Re: North Selby Mine, New Road, Deighton

Ref: AOD/23/00105 (19/00078/OUTM)

Date: 17.04.2023

From: Eleanor Sorfleet, Countryside and Ecology Officer

LIGHTING STRATEGY SHEET 3 OF 3

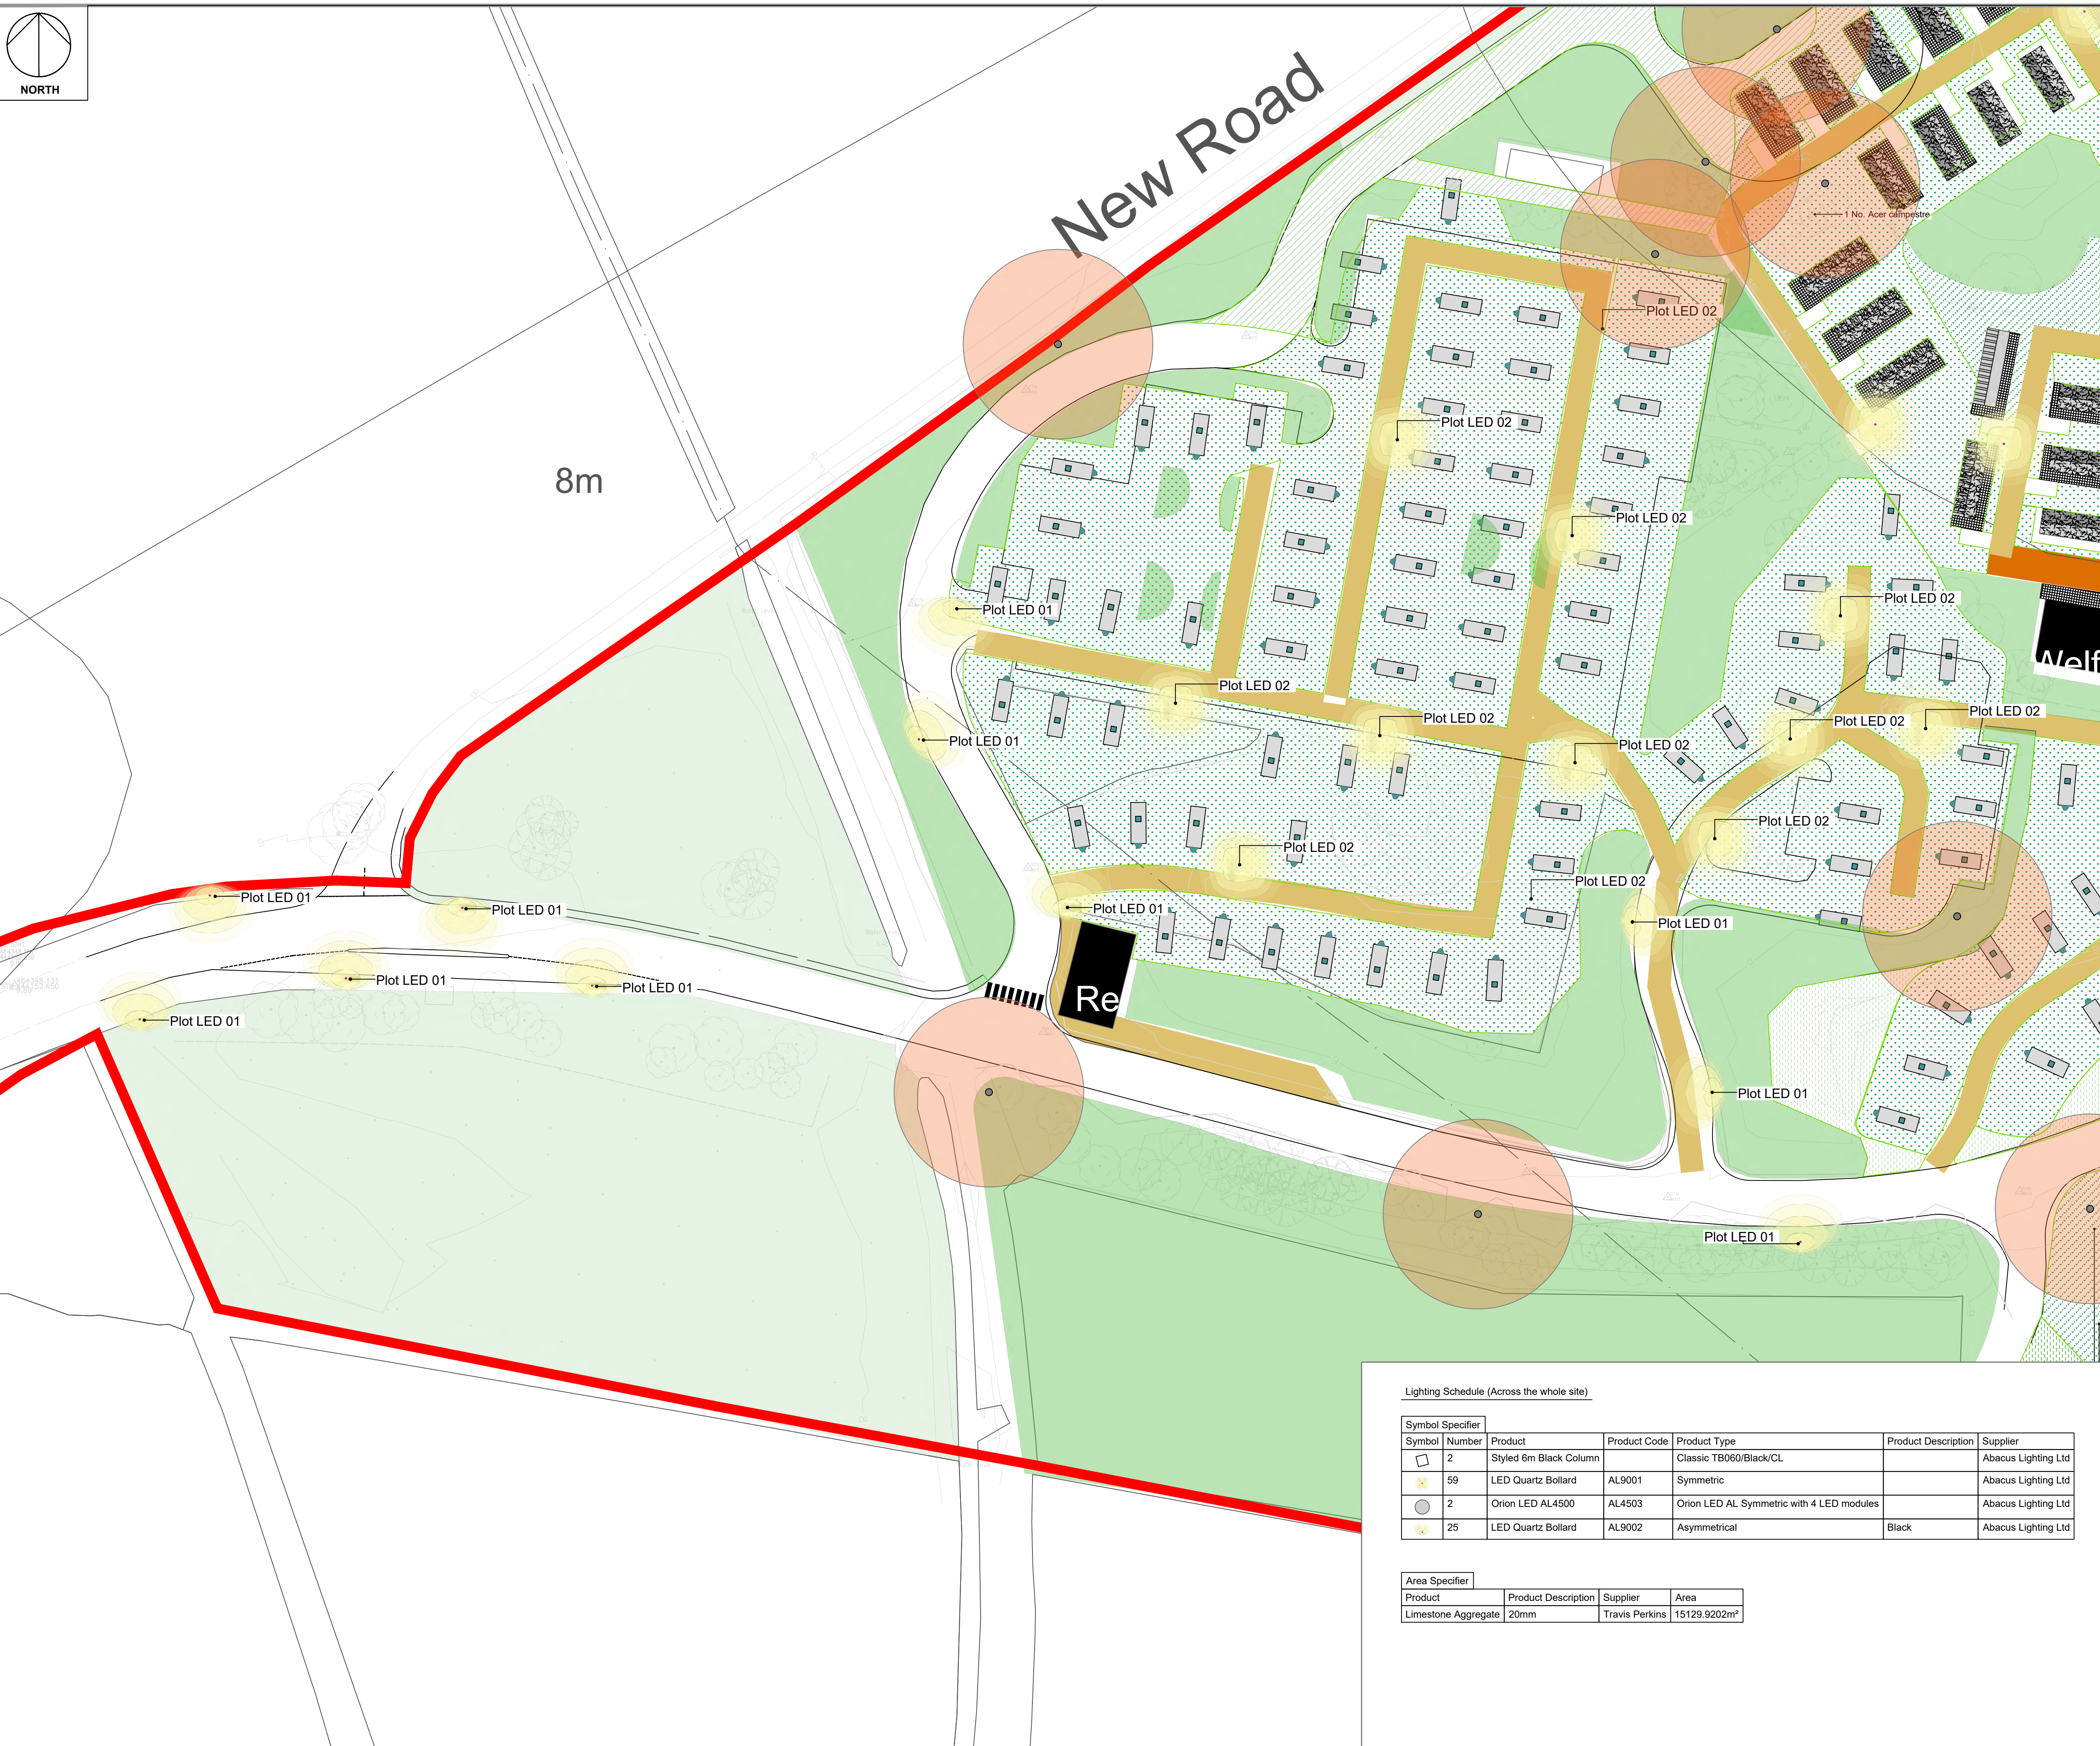
From the information provided it is not clear how the proposed lighting will impact sensitive habitats. It is therefore recommended that a lighting contour plan is provided. The plan should demonstrate light spill and lux levels that will result from the proposed lighting. Further guidance on lighting is available from the Bat Conservation Trust (2018) - Bats and artificial lighting in the UK. The works shall be in accordance with the approved details. <https://cdn.bats.org.uk/pdf/Resources/ilp-guidance-note-8-bats-and-artificial-lighting-compressed.pdf?mtime=20181113114229&focal=none>.

Condition 31 cannot be discharged until further information is provided.
